Ref: 6/2021/2619/LB
Date: 19/10/2021

HISTORIC BUILDINGS AND CONSERVATION ADVICE

RE: 16 Fore Street, Hatfield, AL9 5AH

The application is for the installation of a wall mounted street light including wall bracket, cabling and conduit on the front

IWP No.					Drg. No.			Rev.																
					Fore Street Hatfield 1300 02																			
Project Title					Proposed Street Lighting Equipment																			
Drawing Title					16 Fore Street Hatfield																			
Sht No.					1 of 1																			
Scales					NTS

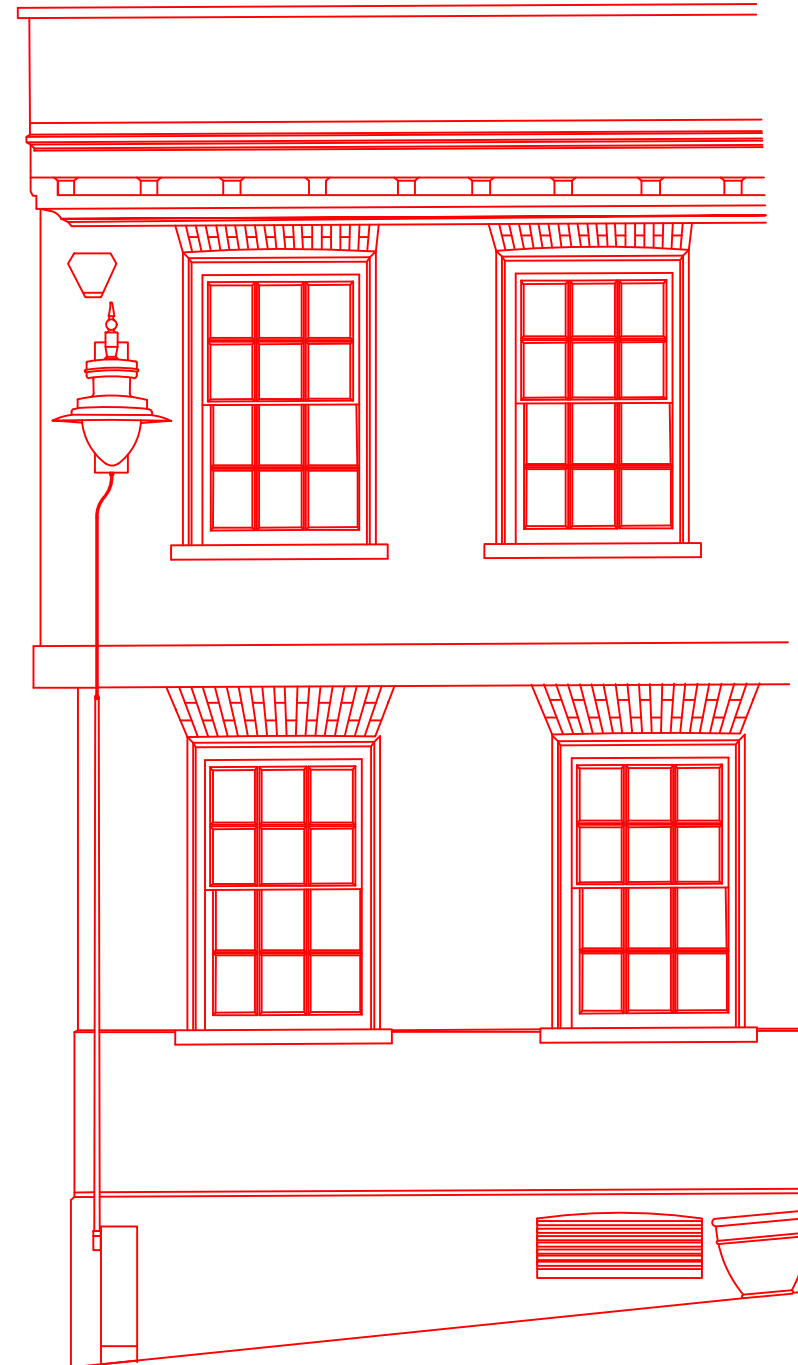
The removal of the existing streetlamp on no.18 is a positive change. The proposed replacement lamp is mounted on a bracket beside the first floor window of no.16 has a traditional appearance. It is also proposed to install a feeder pillar to the base of the wall and a conduit running between the lamp and pillar. The design of the proposed streetlamp matches the proposed replacement lighting at other properties along Fore Street (subject to separate applications) and the consistent approach to the upgraded streetlighting is of benefit to the preservation of the character and appearance of the Conservation Area.

Overall, the proposed design is not intrusive and is sympathetic to the traditional character of the streetscene. The proposed feeder pillar (to be coloured black) introduces an additional modern fixture to the front elevation, which is not ideal, but the proposed black colour will blend with the black painted plinth and its visual impact will be minimised. The streetlamp is also a reversible addition to the building.
